19th February 2021

Town & Country Planning Act 1990 (as amended)
Town & Country Planning (Tree Preservation) (England) Regulations 2012

Application No: FG/170/20/T
Site Address: Verge opposite 18a Ocean Drive The Poplars Ferring BN12 5GJ
Description of works: Various works to 6 No. Austrian Pine trees.

Plan showing location of trees

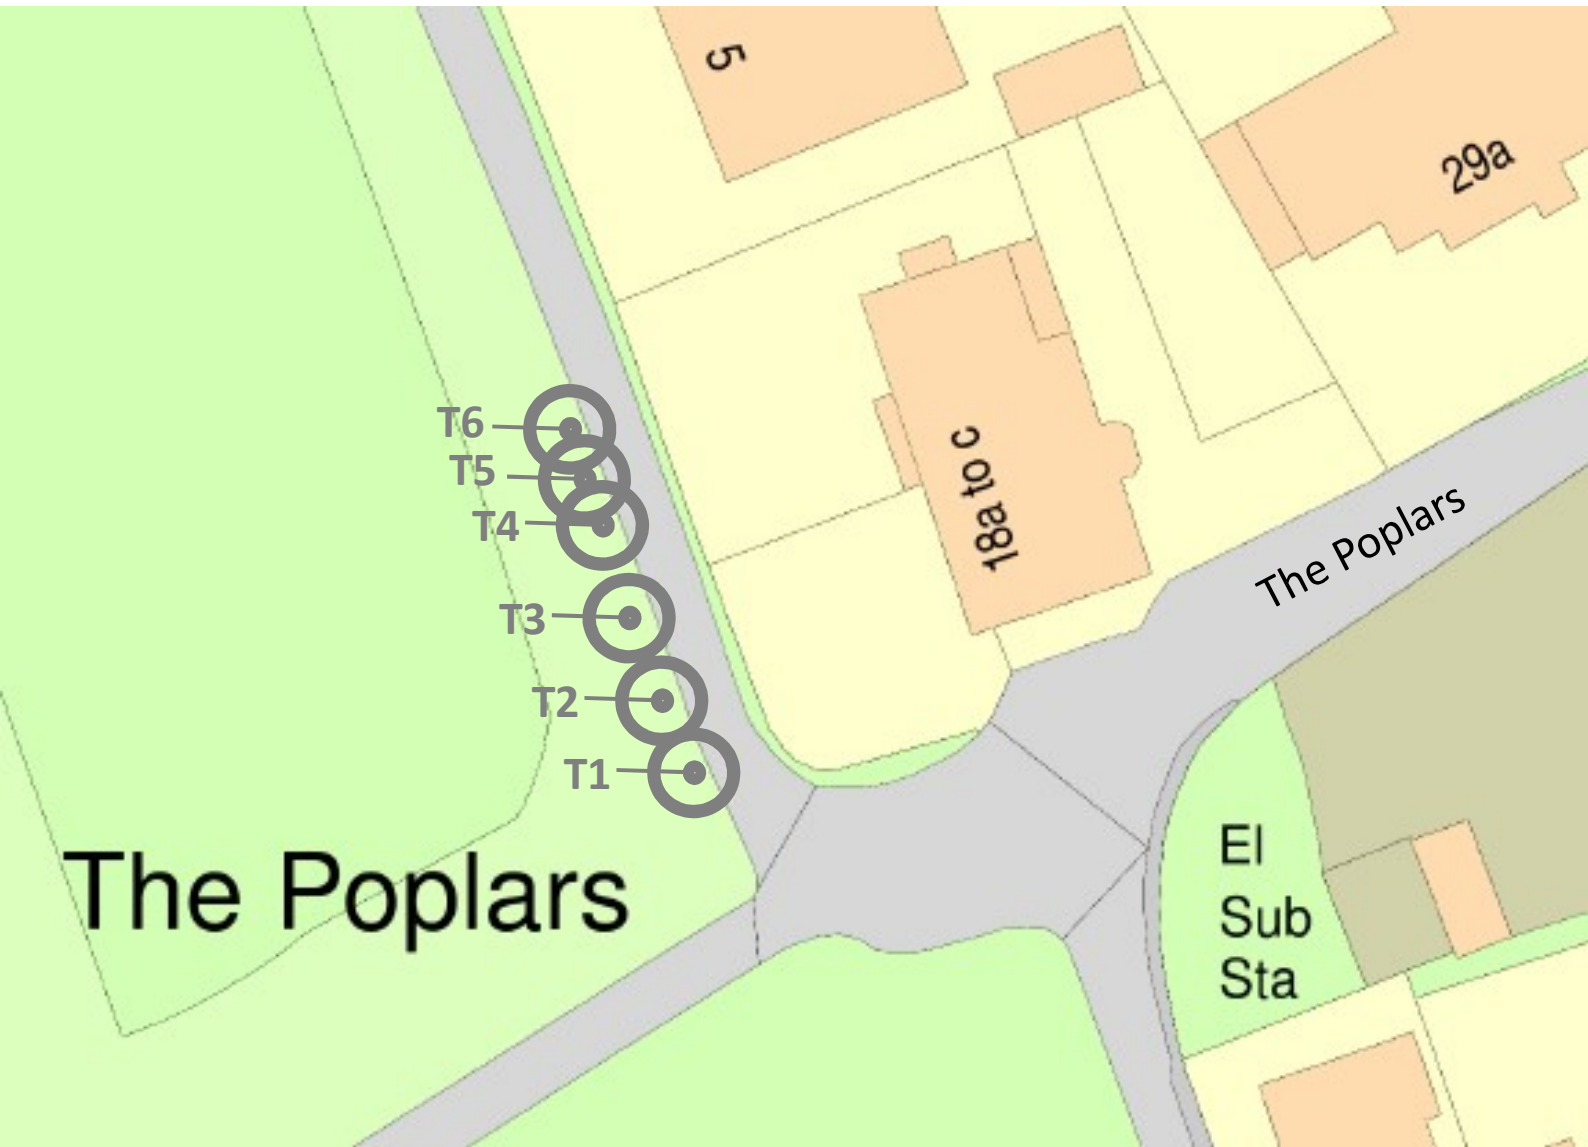
I object to the above application as the trees in question form part of a group of mature protected trees within the Poplars environment. They are visible from many surrounding roads and properties. Any pruning of this nature will result in what has happened in the past viz: leaving trees in a lop-sided and potentially unbalanced situation. I can understand the wish to shorten the odd overhanging branch and the description of work in this application does differ slightly from the previously refused application. However, I am concerned it far too excessive and could still be open to interpretation resulting in them, like other trees so treated, being left unbalanced and unnatural in appearance.
